From: Amanda Scholes on behalf of Planning.Responses
Sent: 07 November 2017 08:49
To: Planning Scanning
Subject: FW: WA/73/17/OUT - Land East of Wandleys Lane and West of West Walberton Lane, Fontwell.

Application No: WA/73/17/OUT

Site: Land East of Wandleys Lane and West of West Walberton Lane, Fontwell.

Proposal: Outline Planning Application with some matters reserved for up to 157 No. residential dwellings including 30% affordable. This application is a Departure from the Development Plan.

Appendix N A29 / A27 Mitigation

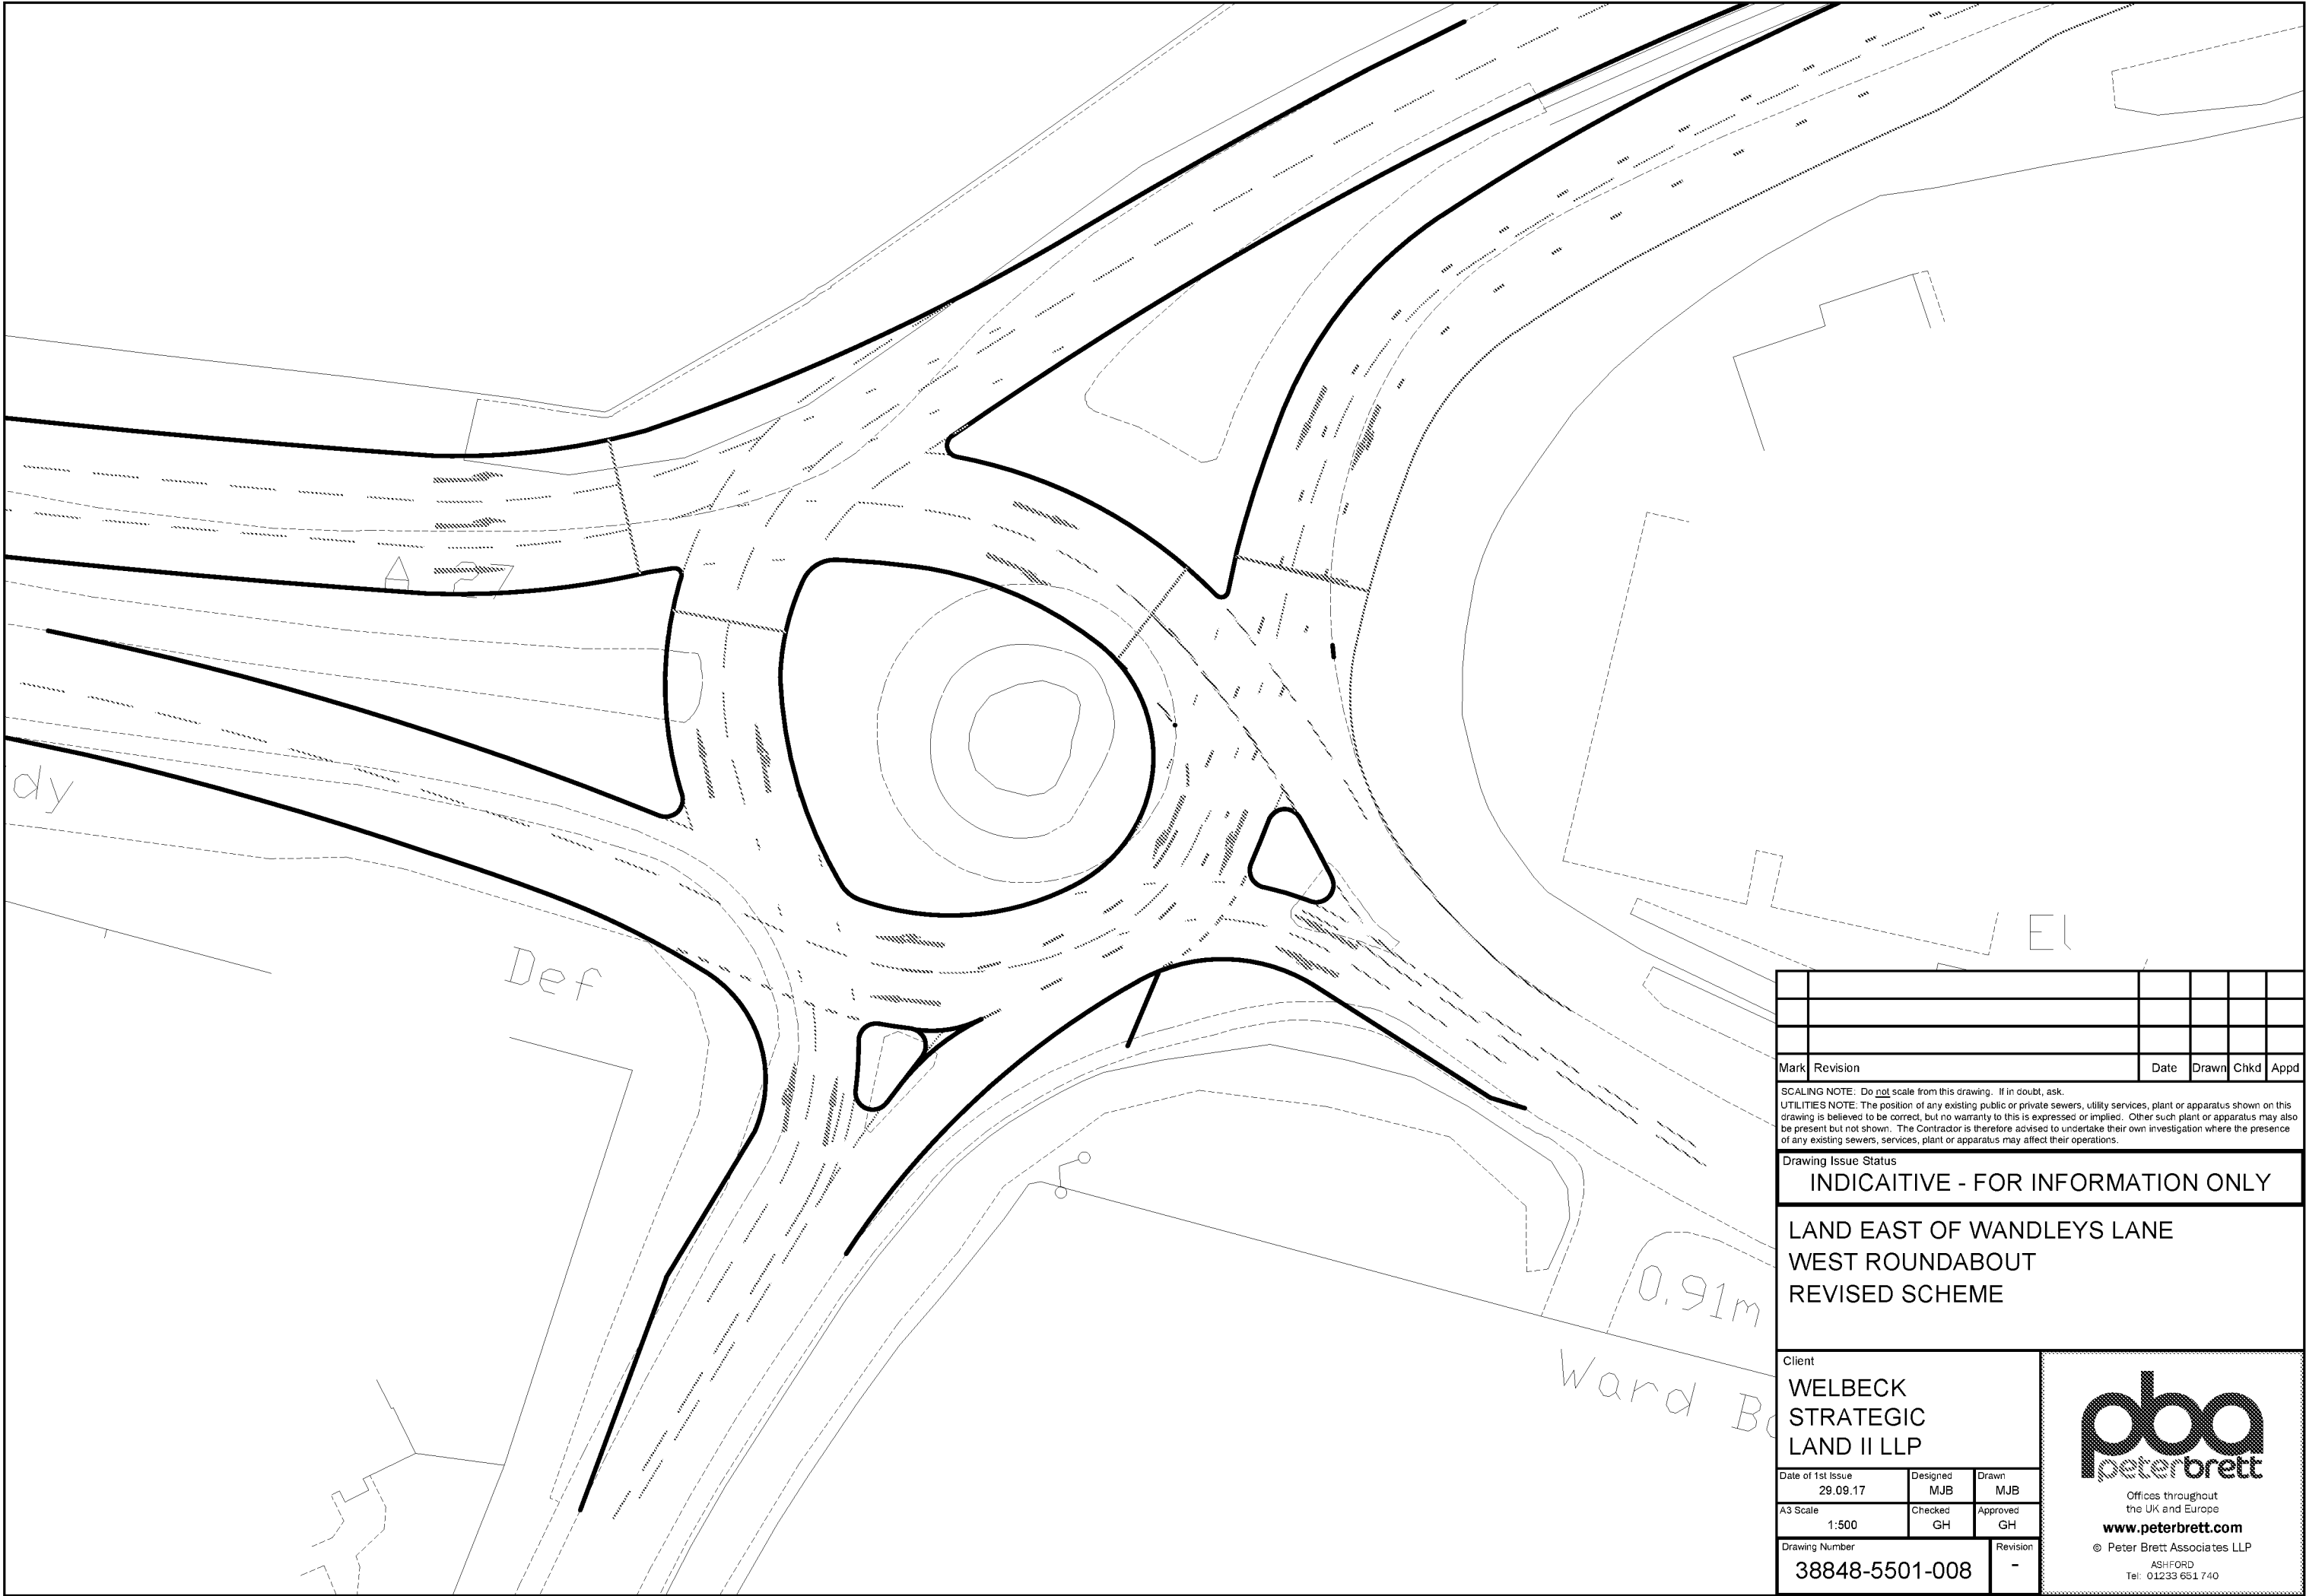
A29/A27 Mitigation - Linsig

- The modelling files are requested to make a full assessment of the modelling.
- Our initial analysis of the geometry suggests: Lane 2/2 's physical lane length in the model is too long. There is 127 metres to the next junction and the model has a lane length of 60 PCU. Lane 3/1's physical length seems to be too long - it appears to be around 3 PCUs. Lane 4/1's physical lane length is too long – it appears to be around 10 PCUs.
- All circulatory lanes are modelled as having a physical lane length of 60 PCUs, and thus this should be amended as it is incorrect.
- Clarification is sought as to whether saturation flows are geometrically calculated or directly inputted?

Appendix O A29 / A27 East Roundabout

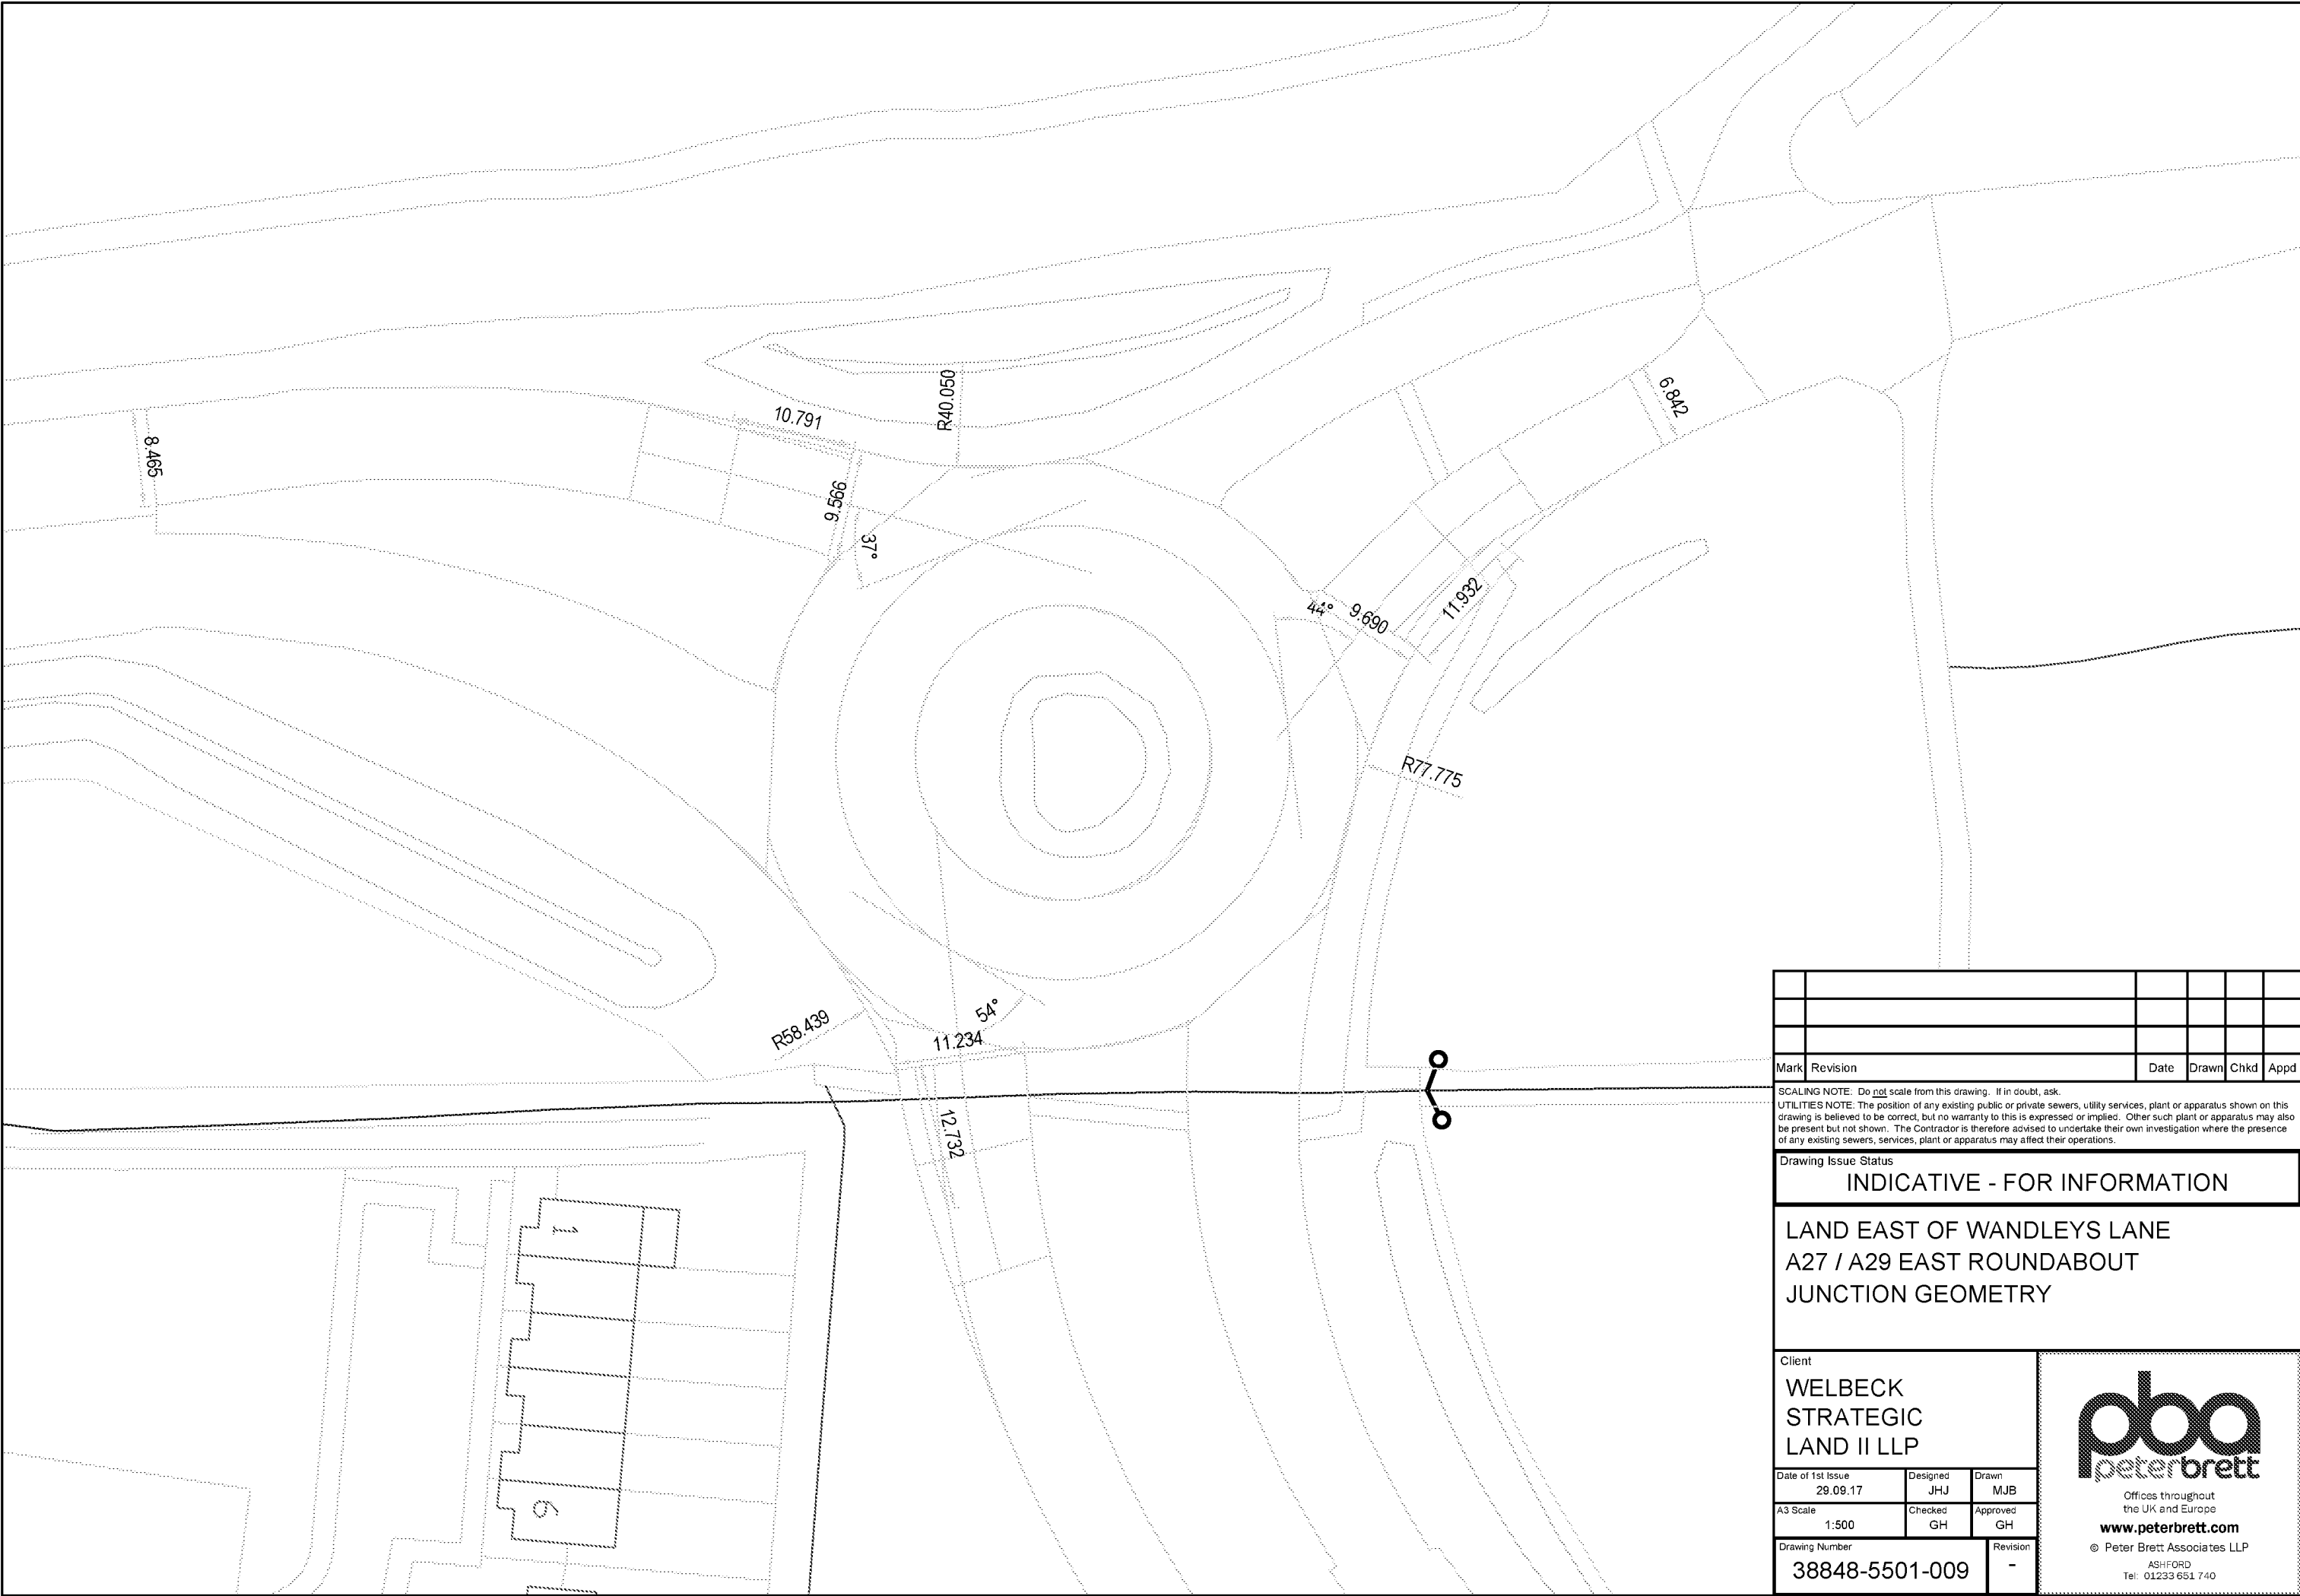
A29/A27 East Roundabout - Junctions 9

- The modelling files are requested to make a full assessment of the modelling.
- The only results presented are for the 2031 Base + Dev PM (16:15-17:45) scenario and thus the results of the other scenarios are requested
- The traffic input is in Vehicles not PCUs. However, the LINISG inputs are in PCUs and thus clarification is sought on this.
- The traffic flows input do not appear to match the traffic flow diagrams in the appendices.
- Geometry: our initial analysis suggests that there are some discrepancies as follows:

Arm	V	E	L'	R	D	PHI
1-A29 East	6.84 (too	9.69	11.9 (too	77.8	51.6	44.0

large)		short)			
2 – A27 South	8.00 (too large)	11.23 (too wide)	12.7 (too short)	58.4	51.6	54.0
3 – A27 West	8.47 (too large)	9.57	10.8	40.1	51.6	0.0
